ST ANTHONY OF PADUA SSD -8865 - RESPONSE TO REQUESTS FOR FURTHER INFORMATION

This letter supports the Response to Submissions report (RTS) provided to you on 18 November 2019 in respect of SSDA_8865 for the proposed St Anthony of Padua Catholic School (the Proposal) at 125-165 Tenth Avenue and 140-170 Eleventh Avenue, Austral (the site).

This letter has been prepared on behalf of SCS in response to NSW Department of Planning, Industry and Environment's (DPIE) request for additional information of 9 December 2019 and further request of 29 January 2020.

DRAWING
DETAILED PROPOSAL
STAGE 4 PLAN

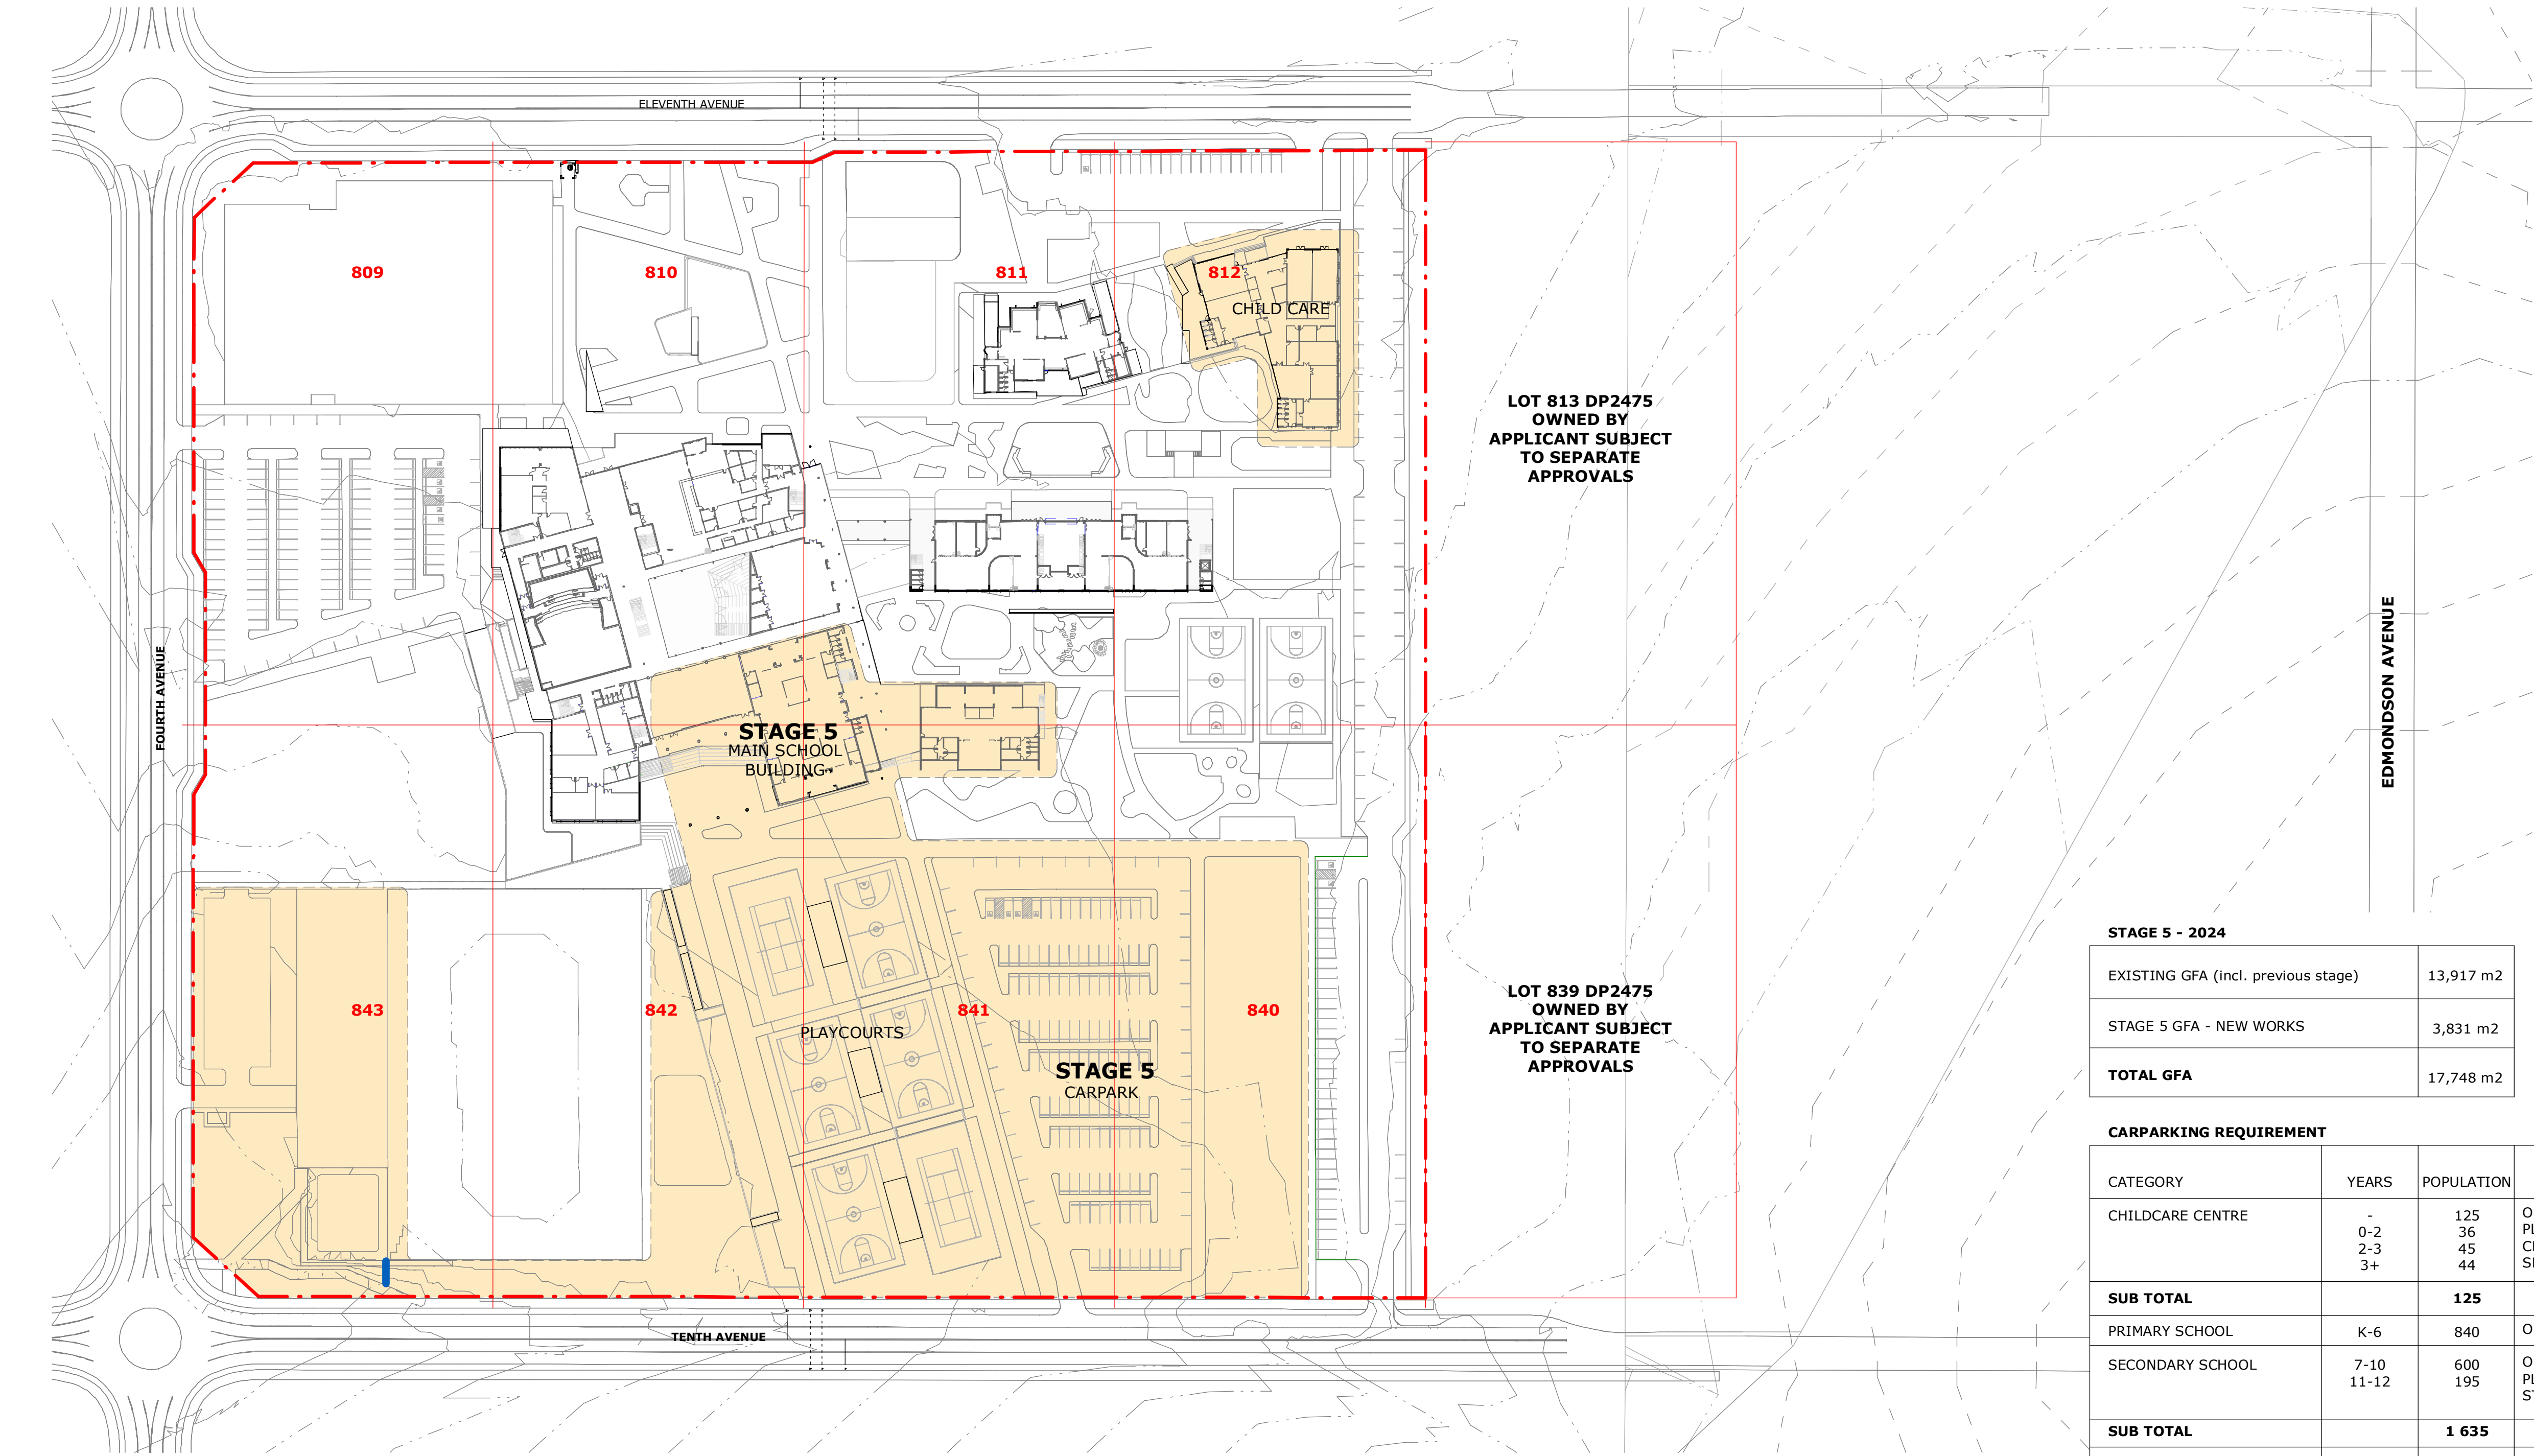
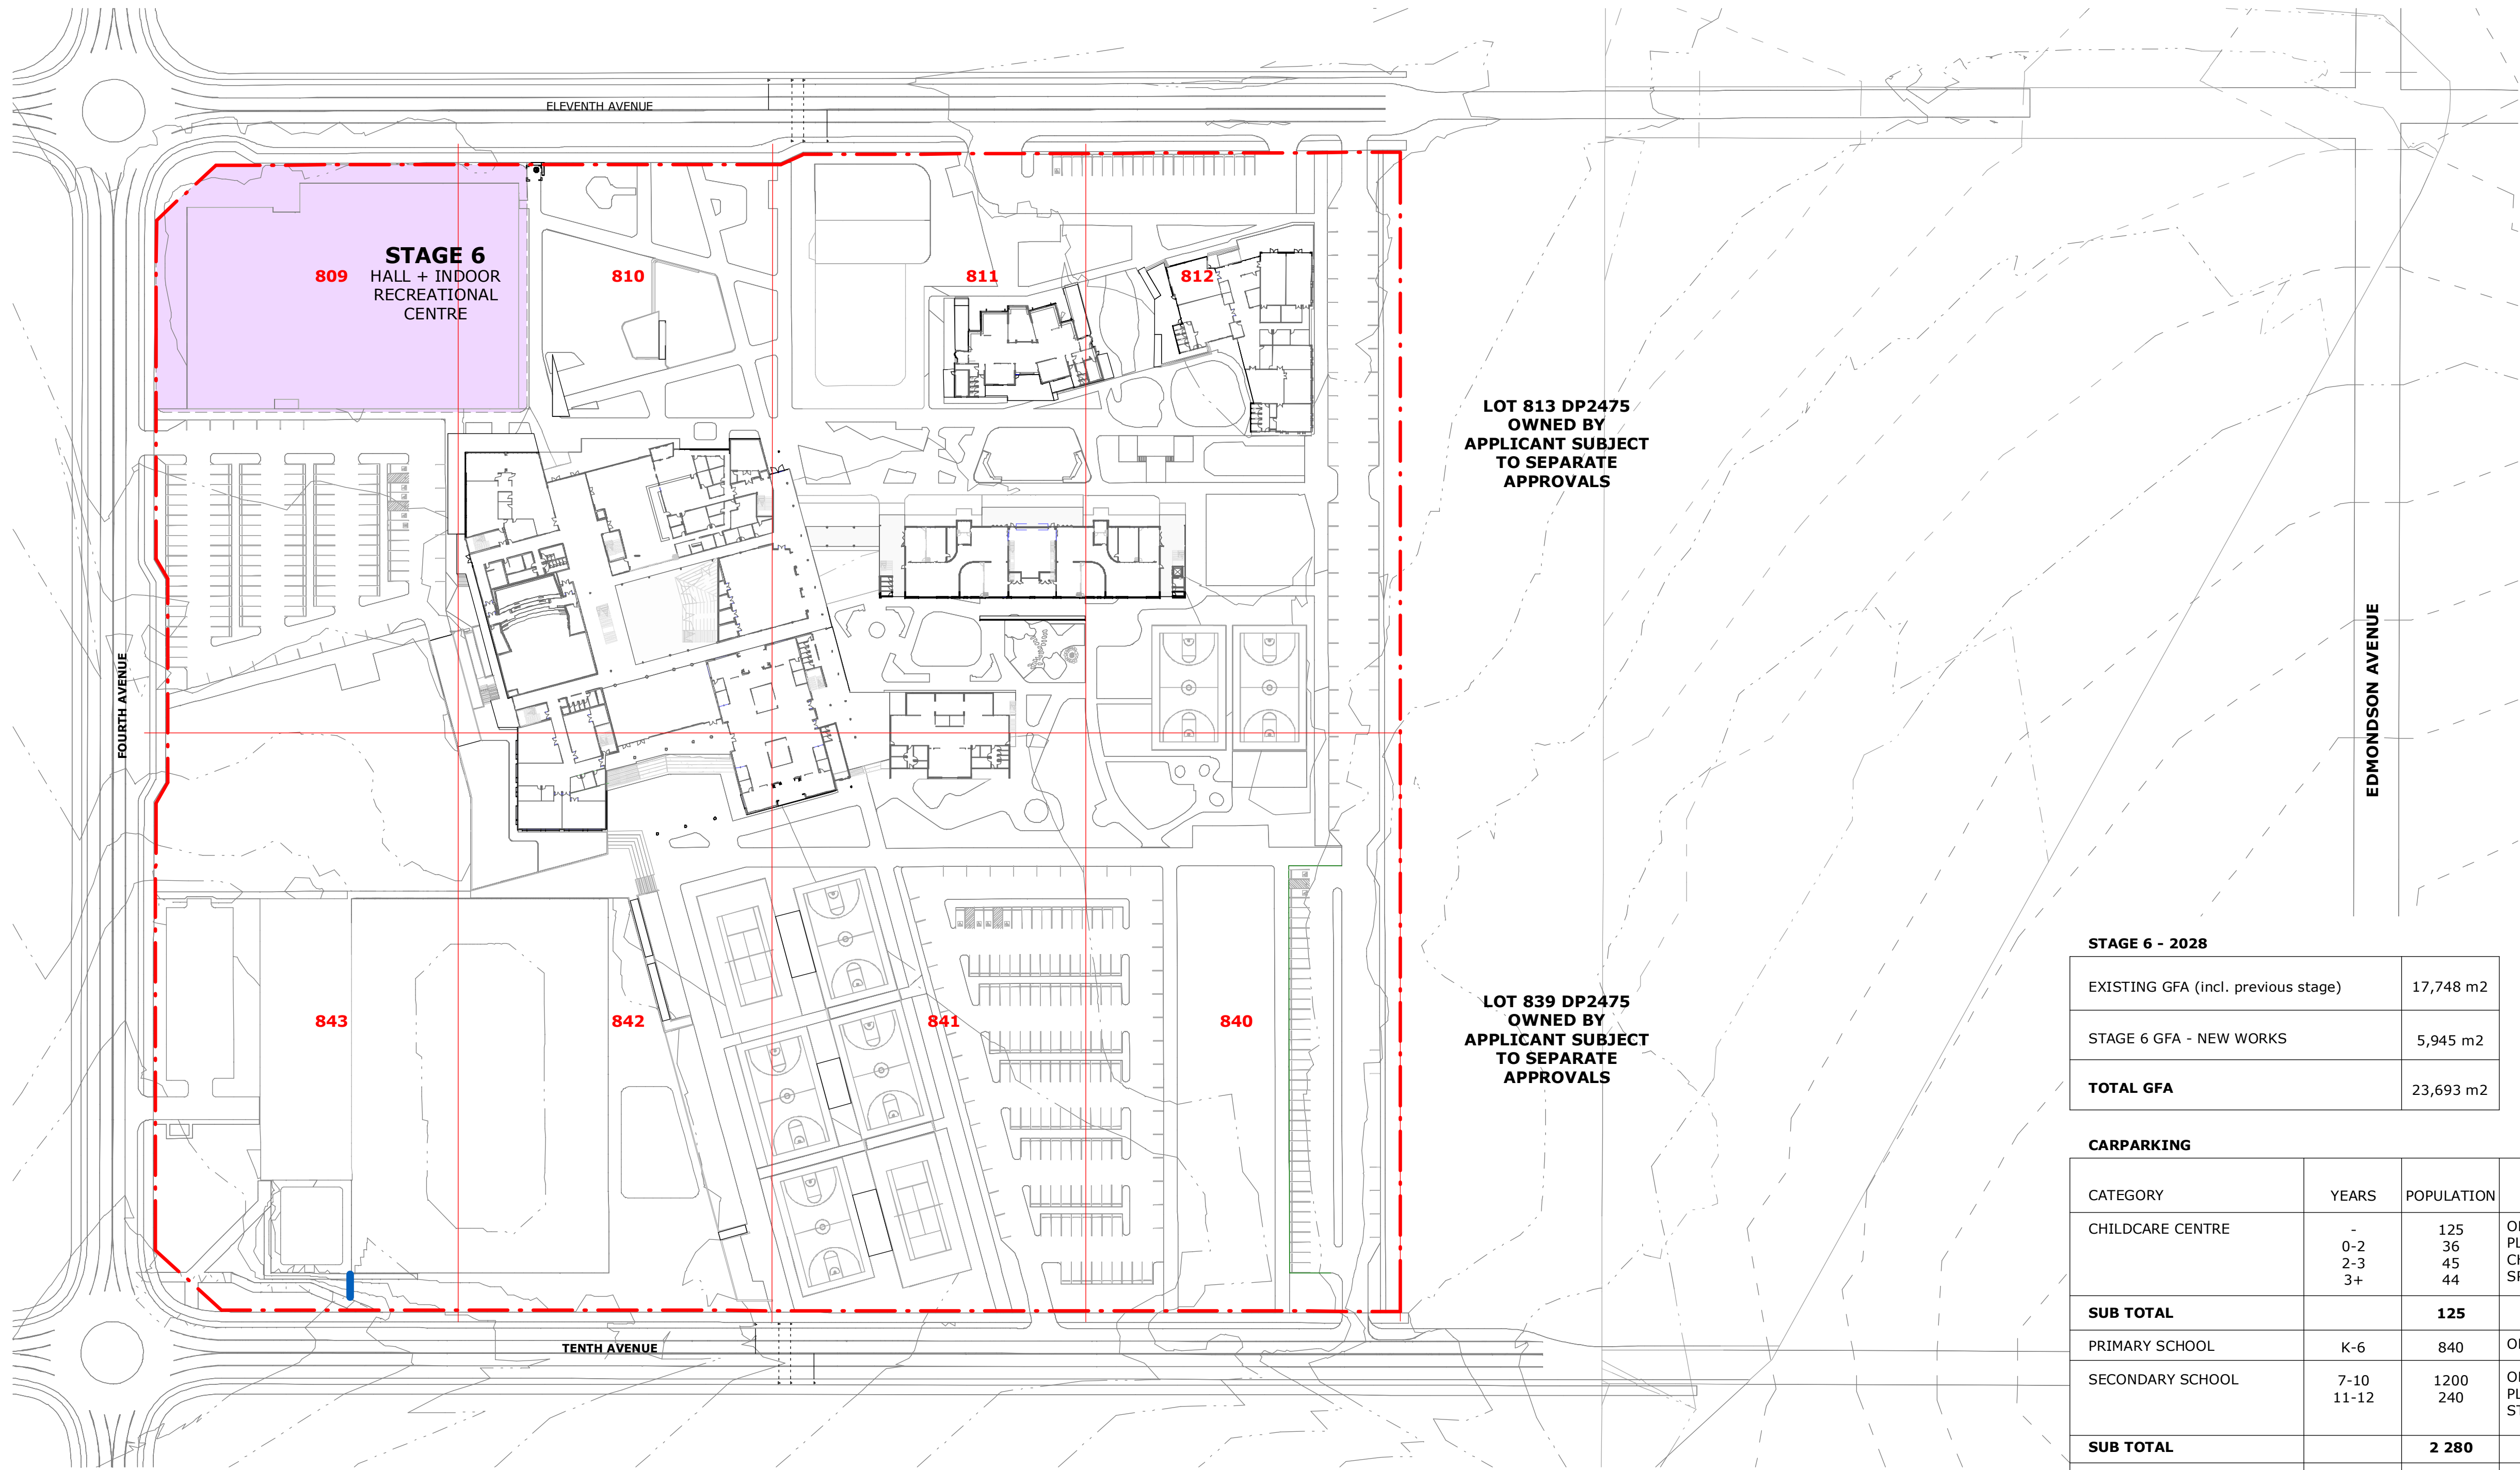
<p>4.4 In addition to student and staff numbers for each stage, the following information are also required for each construction stage:</p> <ul style="list-style-type: none"> the number of drop-off and pick-up spaces, bike parking spaces for each stage and whether the numbers are adequate to cater for the number of 	<p>Amended staging plans have been prepared which provide this information- refer DA052-DA059.</p>	<p>Attachment A- Architectural Plans – refer DA052-DA059 inclusive.</p>

Matter	Response	Refer to
<p>students.</p> <ul style="list-style-type: none"> the gross-floor area for each construction stage. The correct number of car parking and drop-off and pick-up spaces for construction Stage 4 noting that the existing information is incorrect (177 car spaces) as it does not include the proposed 22 drop-off and pick-up spaces. 	<p>Overall site GFA plans have been provided at DA131_R10 and DA132_R10. GFA per stage has also been quantified on the amended staging drawings, refer DA052-DA059.</p> <p>The number of car spaces inclusive of drop/off pick up spaces for Stage 4 is 227 and this has been corrected on DA055_R7.</p>	<p>Attachment A-Architectural Plans – refer DA131_R10 and DA132_R10.</p> <p>Attachment A-Architectural Plans – refer DA055_R7.</p>
5 Road widening		
<p>5.1 The RtS indicates that the proposed development includes road widening of Tenth Avenue, Eleventh Avenue and Fourth Avenue. While Eleventh Avenue is proposed to be fully widened, the civil plans show that Tenth Avenue and Fourth Avenue would only be widened for half of the width. The RtS does not clarify whether the remaining section would be widened as part of this proposal or at a later date. It also does not include reasons for not proposing the road widening for the full width of the road.</p>	<p>The proposal is for the widening of Tenth Avenue and Fourth Avenue along the site frontage. The proponent does not intend to widen the roads beyond the site frontage at any point in the future.</p> <p>The proposal also does not propose to widen the southern side of Tenth Avenue or the western side of Fourth Avenue at this time or at any point in the future. It is unreasonable for the proponent to be made to bear the cost of widening the roads beyond the boundary of the school site or for the cost of widening both sides of Tenth and Fourth Avenue.</p> <p>The proposal to widen the road as shown in the accompanying civil plans is satisfactory to accommodate 4 lanes of traffic</p>
